RE: SUBMISSION REGARDING EIS FOR WESTCONNEX M4 EAST
(Application number SSI 6307)

Architects Contempo has reviewed the voluminous and extensive Environmental Impact Statement for the WestConnex M4 East. Given the short and limited time constraint the noted issues are summarised. Accordingly, we wish to note the following issues and respectfully request that they are adequately addressed with detailed and specific responses:

8.26 TB - DENOTES DESIGN TOP OF BARRIER

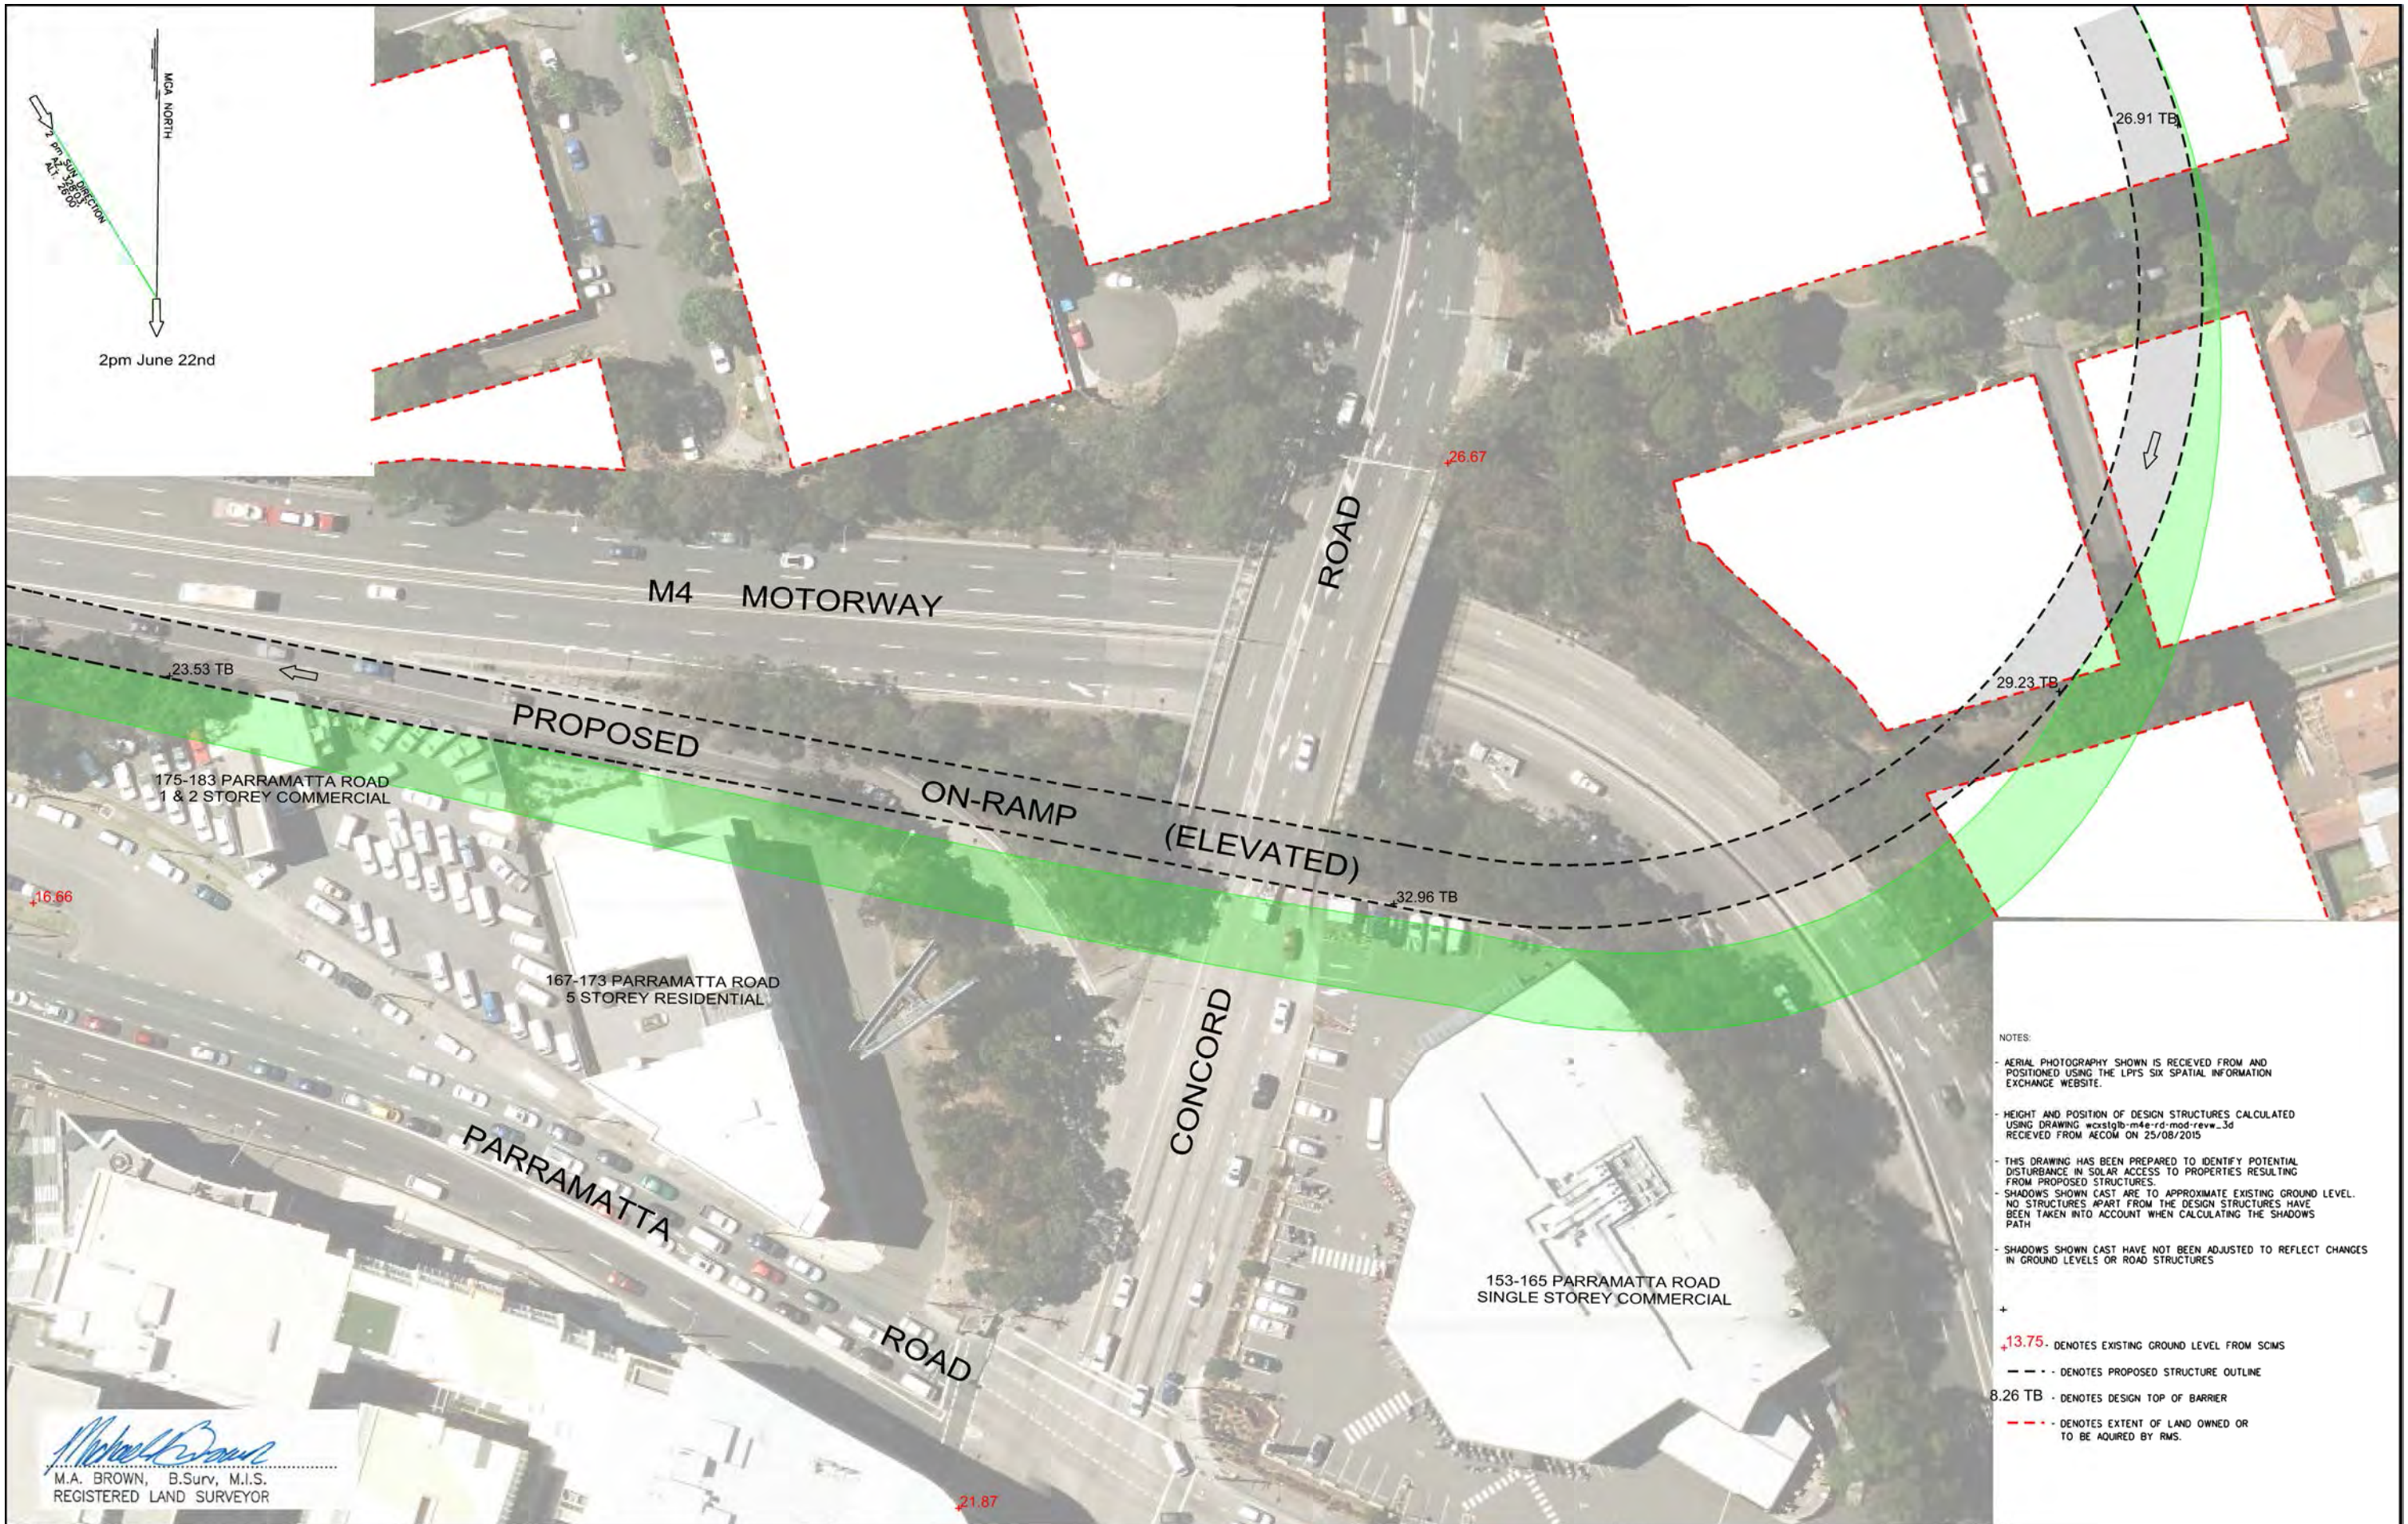
The report does not include respective relative levels and accurate 3D models of the following:

- a) The proposed 3 metre wide footpath;
- b) The adjacent roadway and portal levels; and
- c) The height of the perimeter acoustic barrier walls relative to the existing natural ground levels of the adjoining north facing rear gardens of the abutting subject properties.

The acoustic barrier walls illustrated on the plan diagrams are identified between 3-5 metres in height, with no relative levels associated to the adjoining properties. I am particularly concerned with the overall potential impacts of overshadowing, bulk, relative scale and resultant blocking out of the currently available northerly sunlight will significantly diminish the existing aesthetic qualities, character and nature of our heritage property.

Although we understand that the proposed height of the wall is a necessity to eliminate the anticipated increase in noise produced by the relocated and anticipated increased traffic numbers. Nonetheless, we stress that a high solid wall is both visually inappropriate and would adversely impact of the value and heritage character of our subject property. We respectfully request that future detailed design incorporate a minimum 2 metre transparent glazed section to the top of the proposed noise wall.
